Application No: BN/18/21/RES
Site Address: GTR land east of Fontwell Avenue Arundel Road Arundel BN18 0SB
Description of works: 5000 sq m of light industrial floor space (ClassB1 (b)/(c) following grant of outline planning permission WA/22/15/OUT (resubmission following BN/57/19/RES). This site is in CIL Zone 1 (Zero Rated) as other development.

Thank you for your internet representation made on 16th August 2021 which has been recorded as an objection with the comments as follows:

DATE 23-12-20	DRAWING No. WM/688/P11
------------------	---------------------------

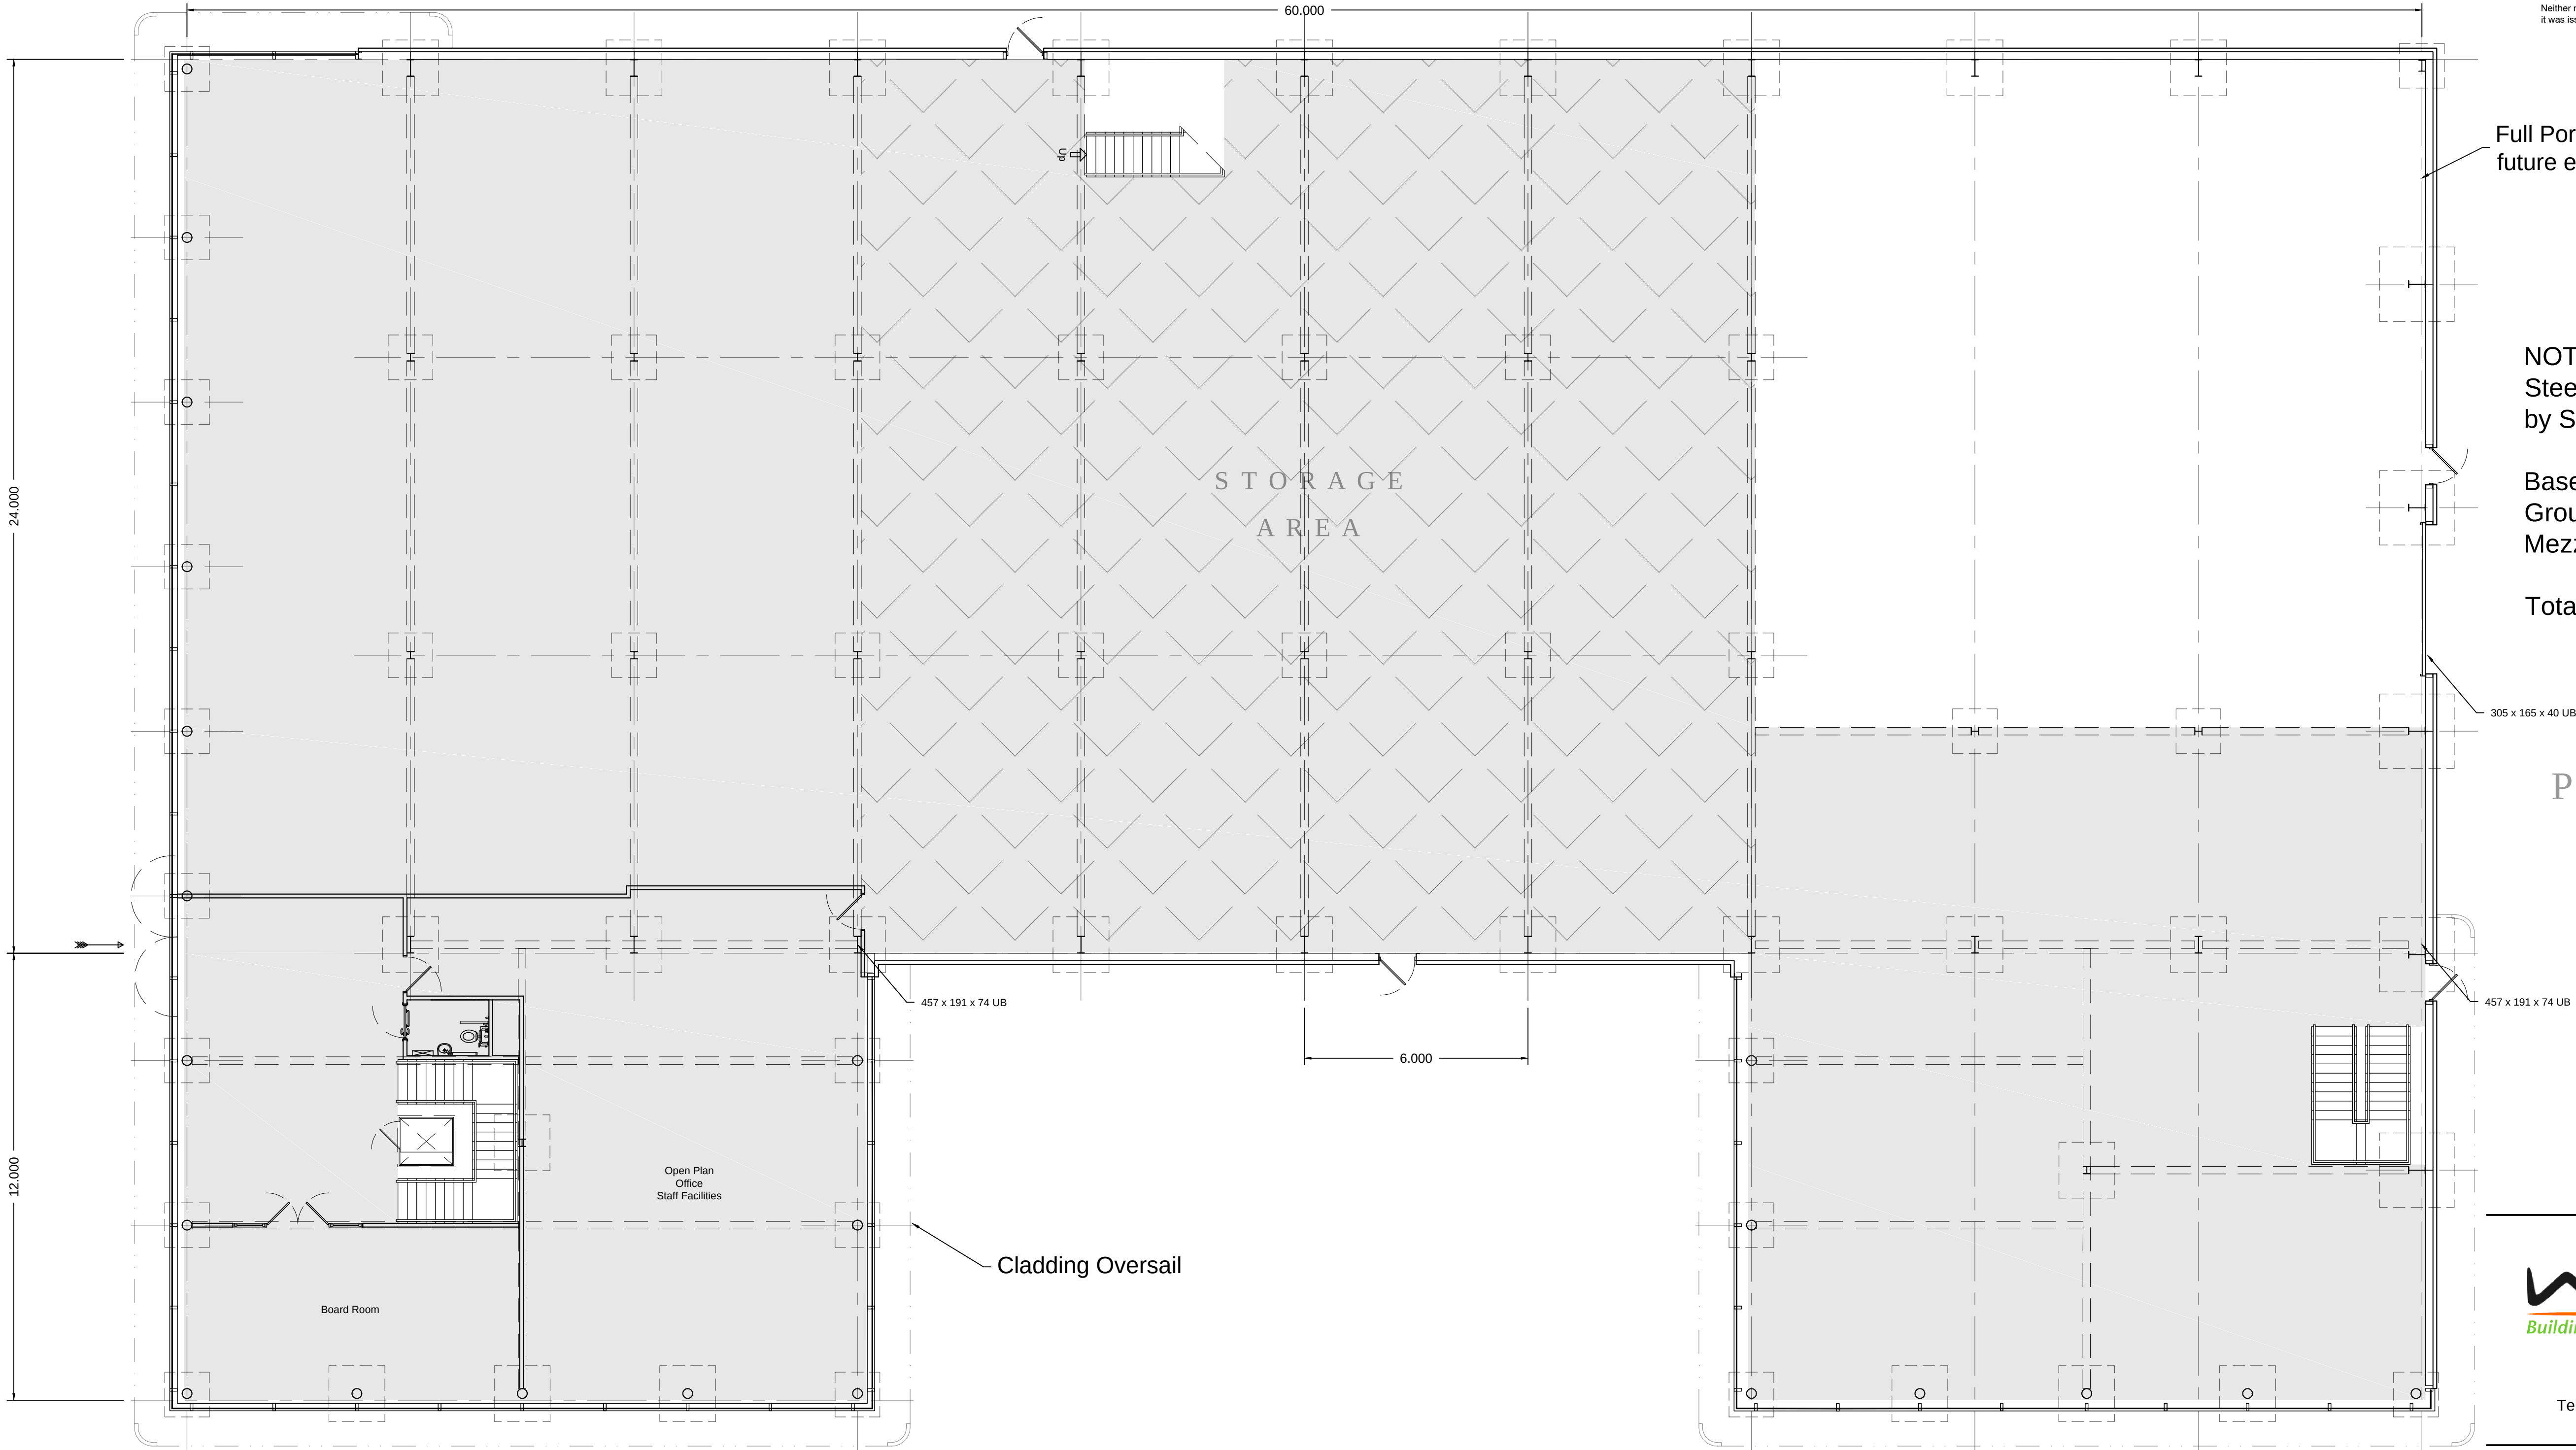
The Design Access Statement refers to, alternately, an eaves height of 8.5m (para 3) and 7.5m (para 3.6). The height shown on the plan (WM/688/P11 - there does not appear to be a plan for Block B) identifies a roof height of 9.45m with a 4 roof pitch. The distinction between the 'eaves height' which is not identified on the plans and the total height of the roof is negligible.

There is therefore a lack of clarity over the heights to be considered and conflict between the documents. This building is immediately adjacent to two existing properties and multiple future residential properties - situated due west of most. Despite the gentle fall of the land, this building is much too high any any increase in height should be entirely unacceptable for the sake interference with the existing properties and for not being in keeping with the local area which (presently and will following completion of the Dandara development) comprise, almost exclusively, residential properties.
